Ref No: DOC18/56755

Modification Request – Norwest Private Hospital Expansion - 11 Norbrik Drive, Bella Vista (SSD 6074 MOD 2)

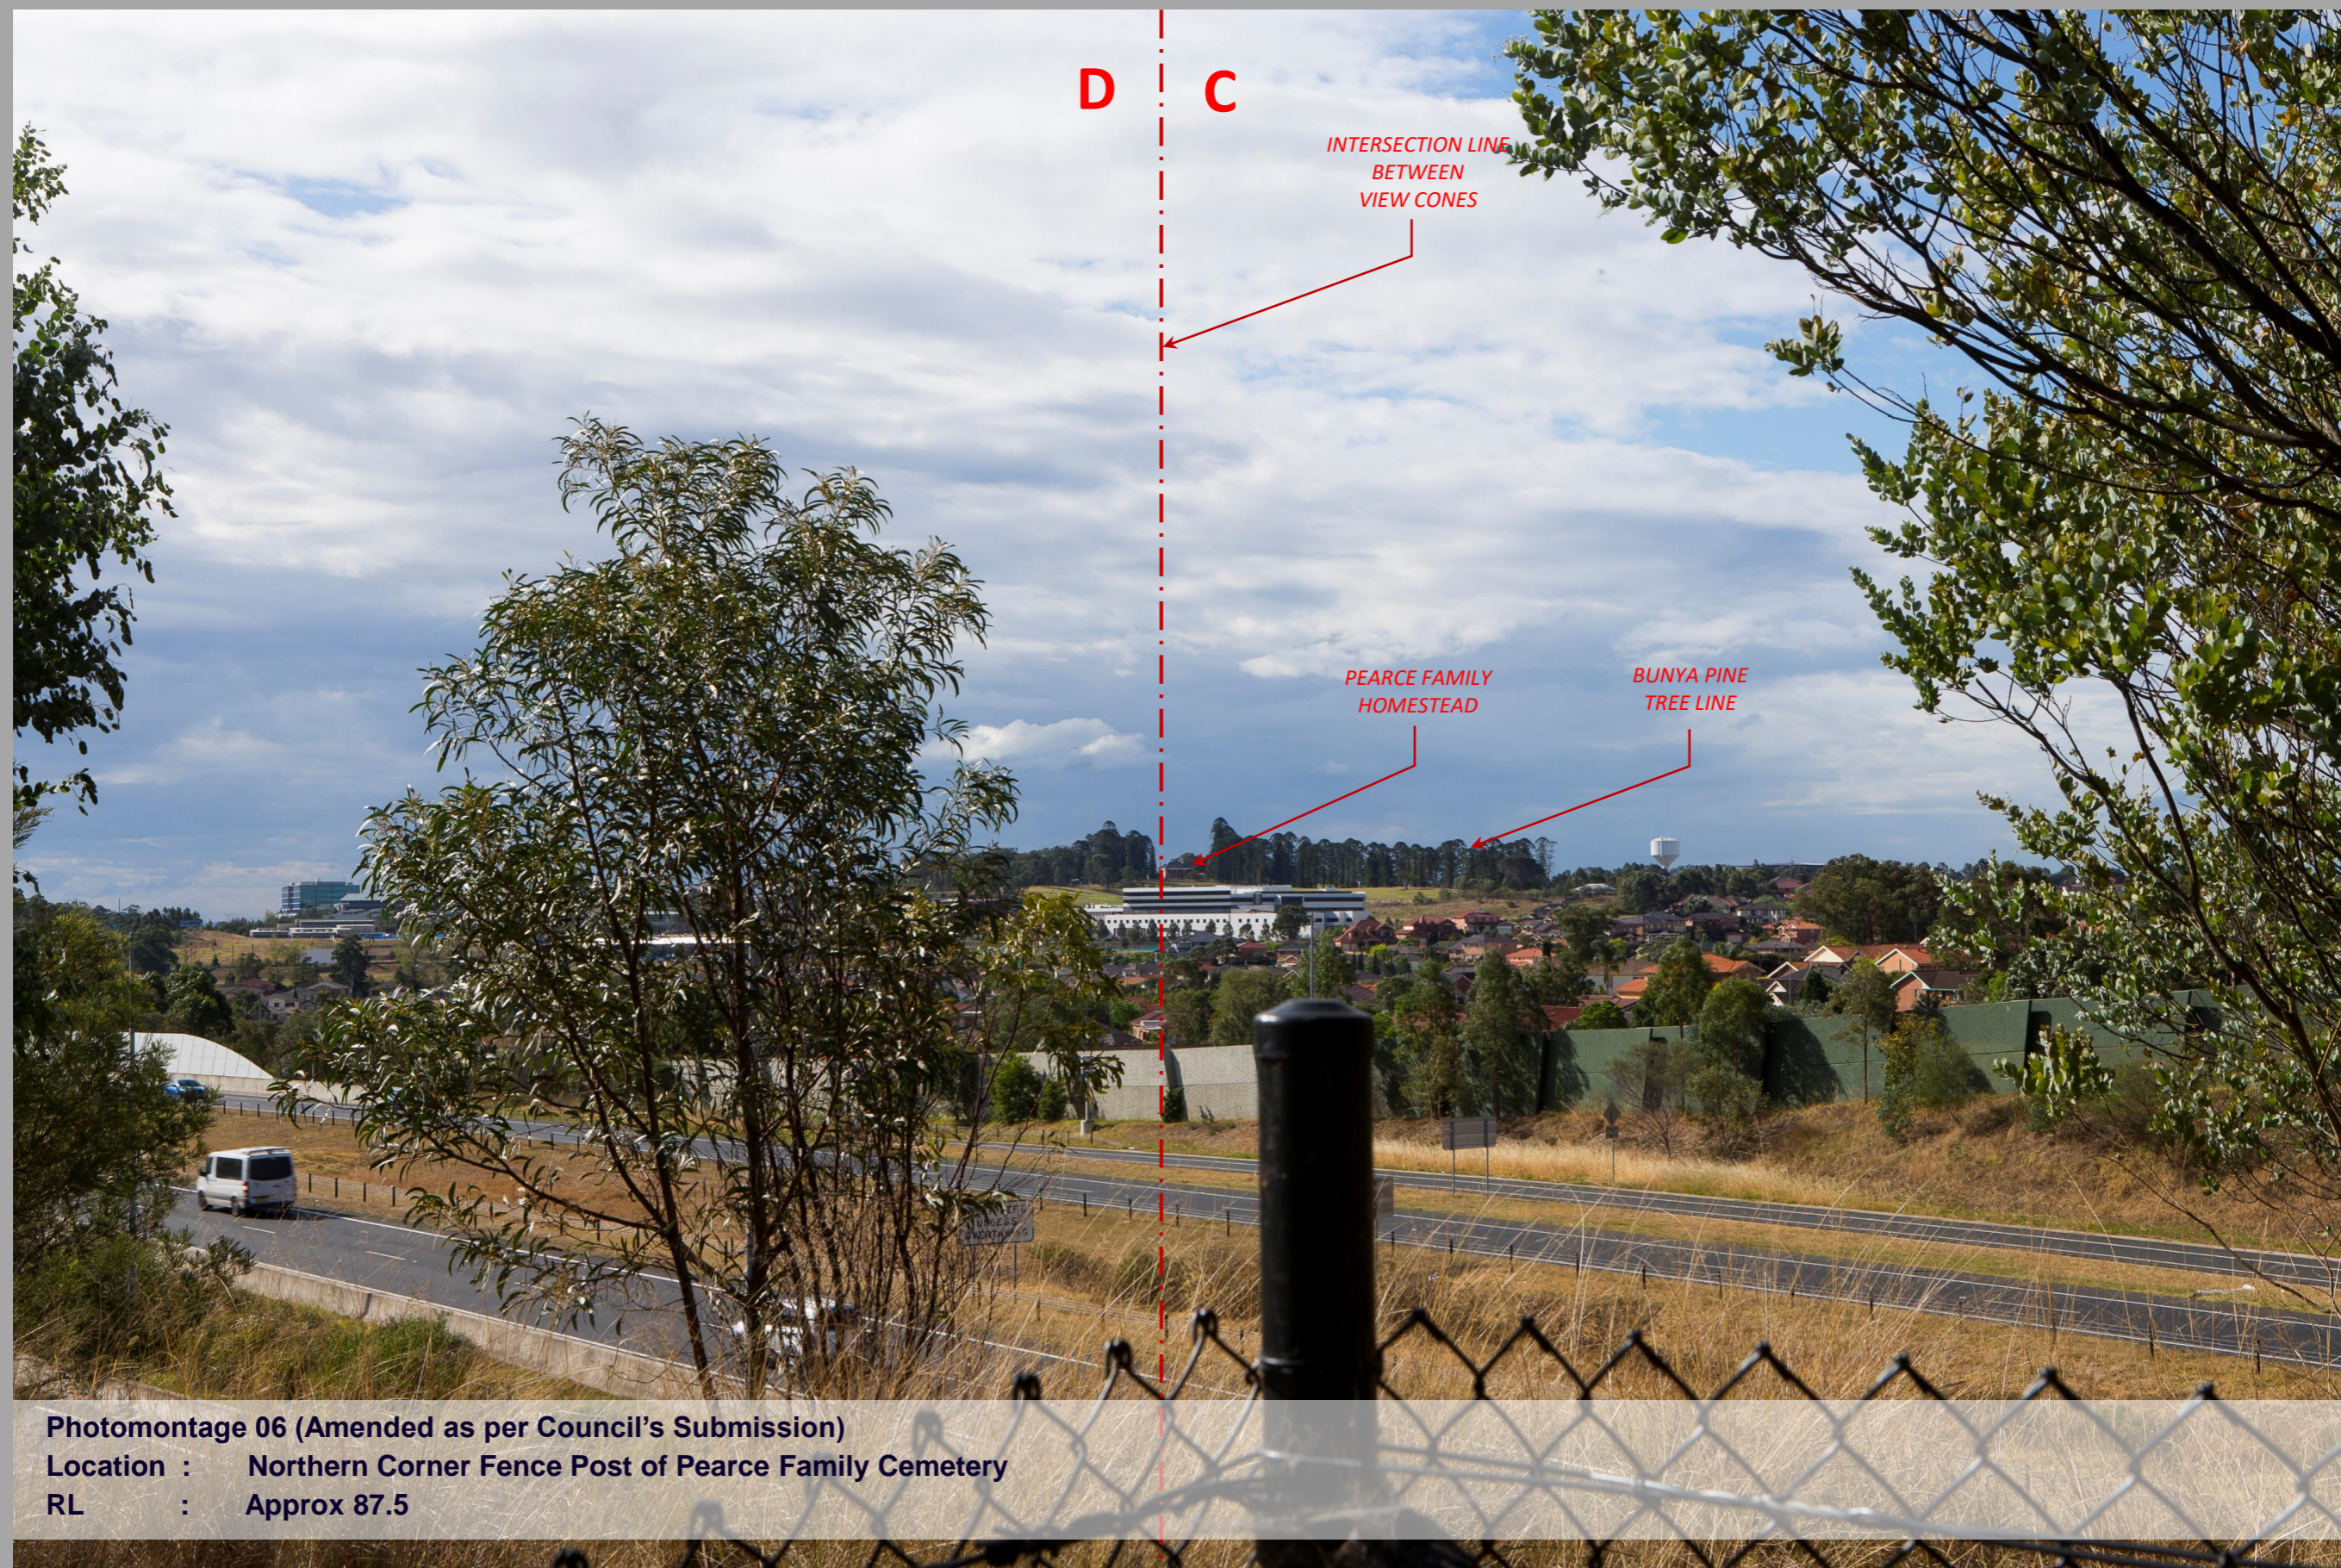
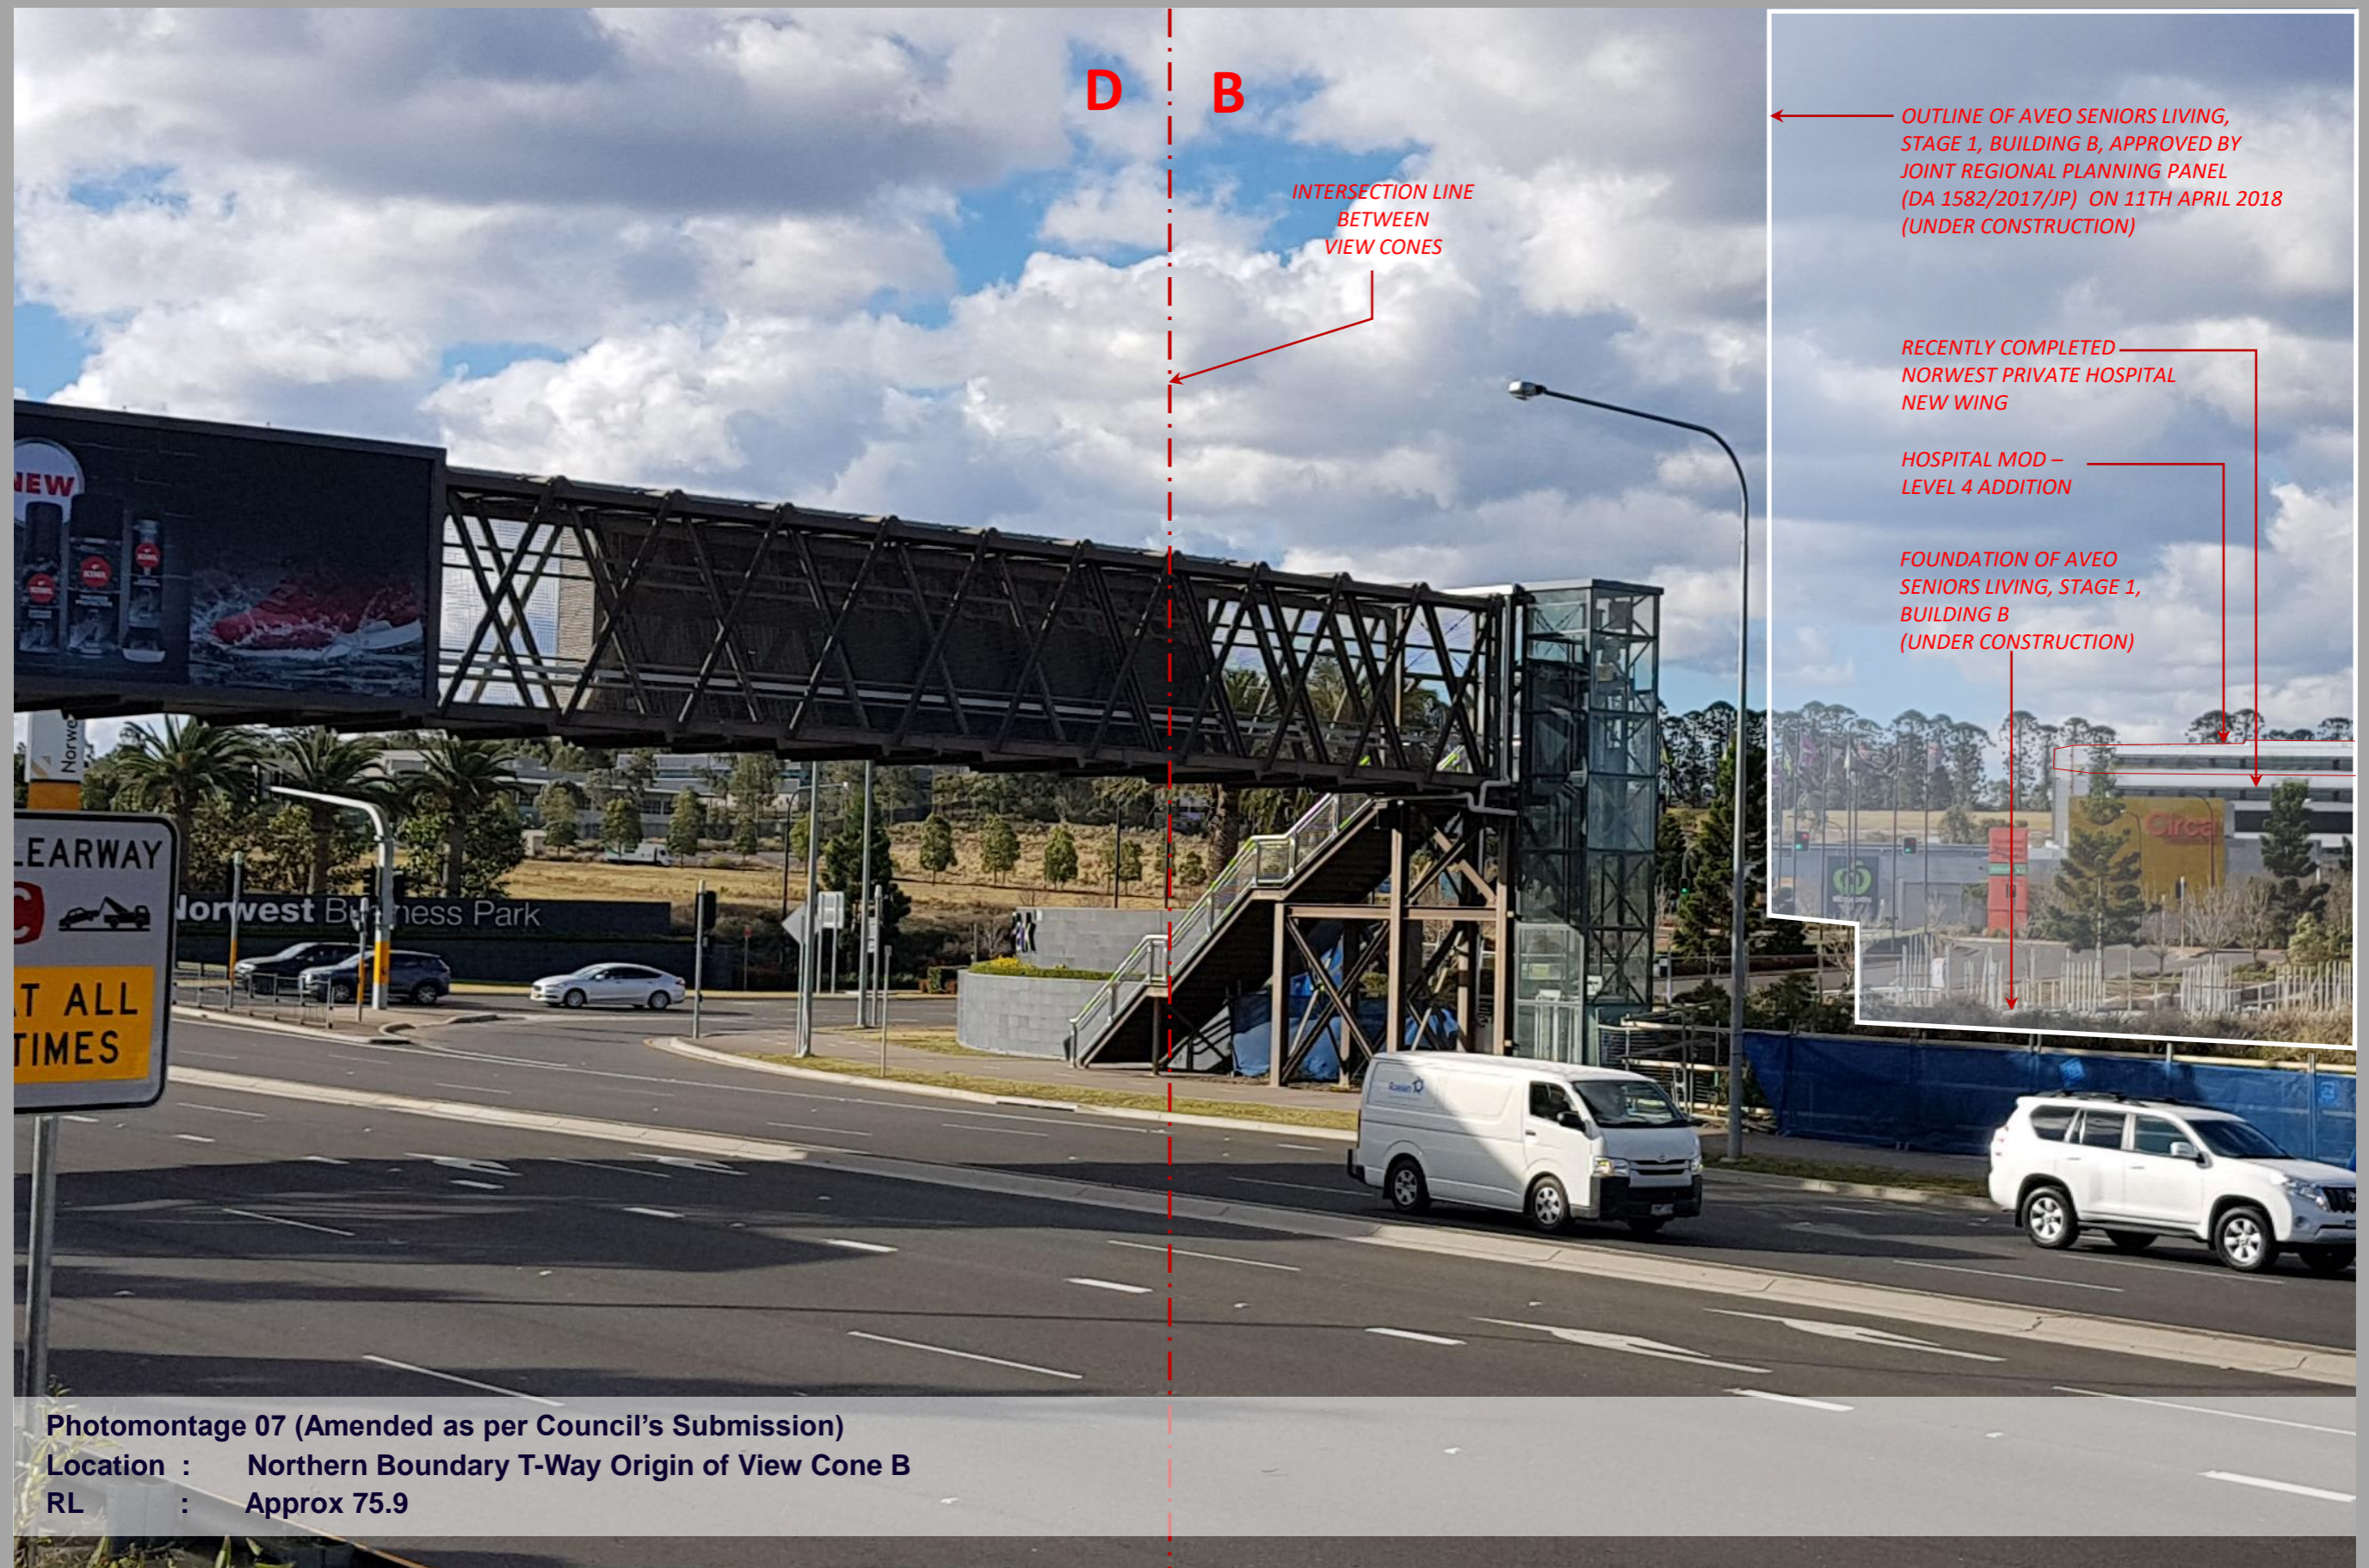
The relevant documentation has been reviewed, including the 'Bella Vista Homestead and Precinct Photomontage Study' prepared by Health Projects International, dated 21 February 2017. The study demonstrates that the proposed addition will retain significant views between *Bella Vista Farm* (including the homestead and Bunya Pine tree line) and the *Pearce Family Cemetery* which is also listed on the State Heritage Register (SHR no. 00593). The retention of these views is essential in understanding the historic association between the two heritage items. Subject to the retention of all identified significant views, no objection is raised.
